KEN BRIGHT ASSOCIATES PLLC
Consulting Engineers

Ref: Lot 63 Blackberry, 145 Knotts Berry Rd., Bunnlevel, NC

Purpose: On Friday, June 23, 2023, at the request of Tony Toro with Lamco Custom Builders, I went to Lot 63 at 145 Knotts Berry Road to make recommendations for the footing where water was found.

STEM WALL FOUNDATION Detail not to scale

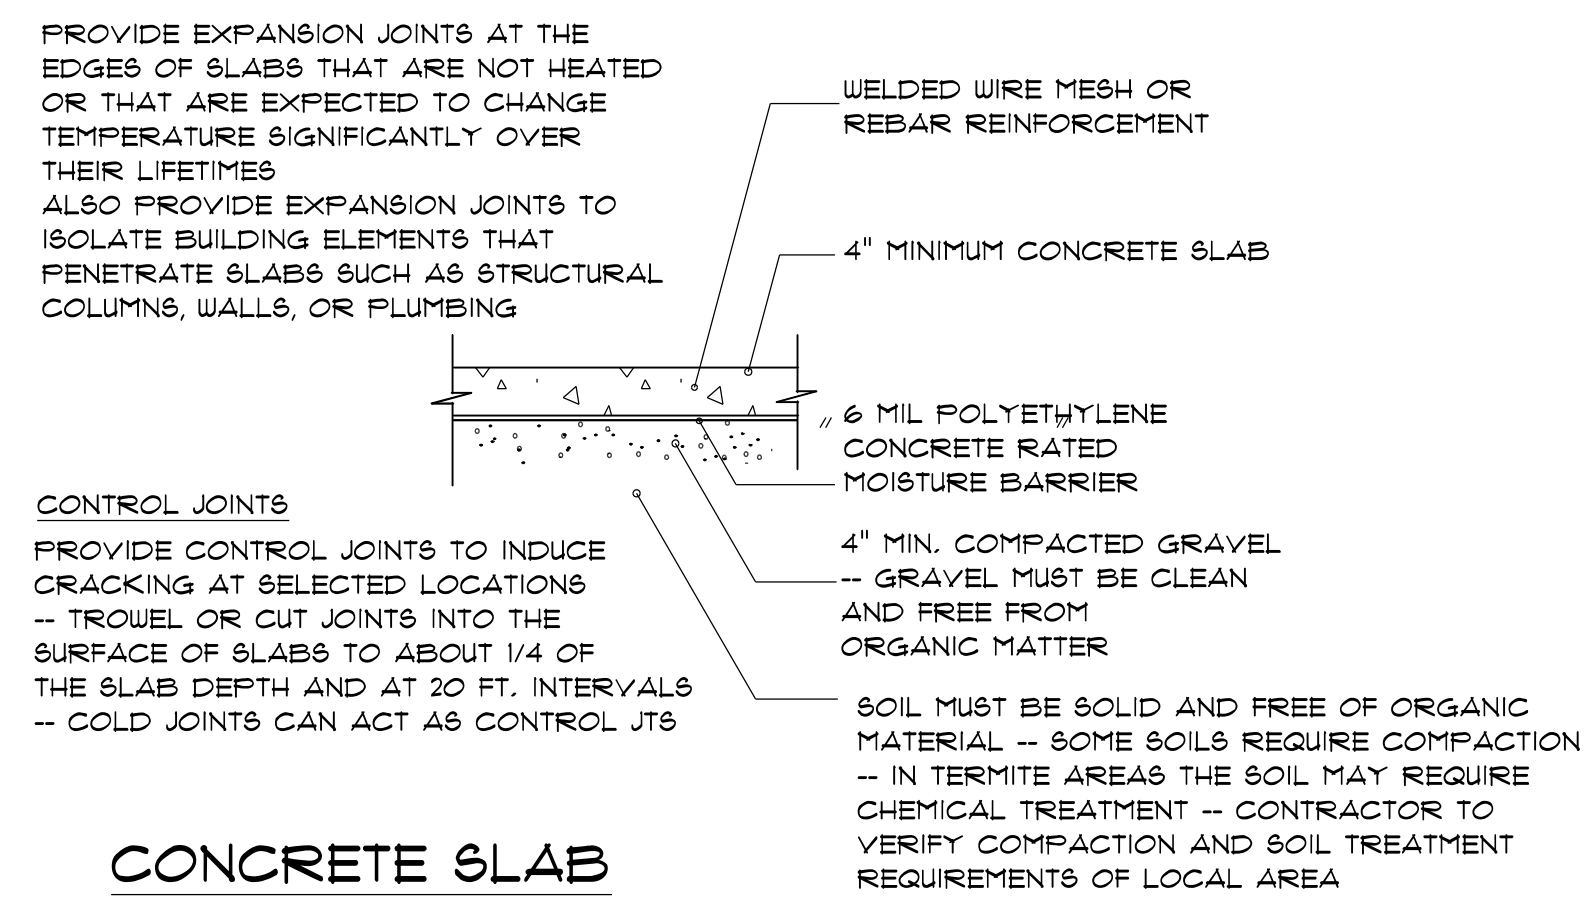
Observation: There was 6" + of water in all trenches. Four to six inches of water was observed in most of the trenches. In 2 places soft soil was found approximately 30" deep in the front right and left rear. I discussed this with this with Tony Toro, the builder, and he thought those areas were probably stump holes. The dug trenches were approximately 16" wide.

Recommendation: We recommend pumping out the water in the trenches as much as possible and removing all soft areas including any stump holes. Also, we recommend placing a non-woven filter fabric to wrap the trench and add a minimum of 8 inches of #57 or #67 stone. Stump holes to receive full depth stone. We instructed Mr. Toro to install 2#4 rebars 3" to 4" from the bottom in all trenches prior to pouring any concrete.

Once inspected by the building inspector, we recommend placing a minimum pf 8 inches of 3000 psi concrete in all trenches.
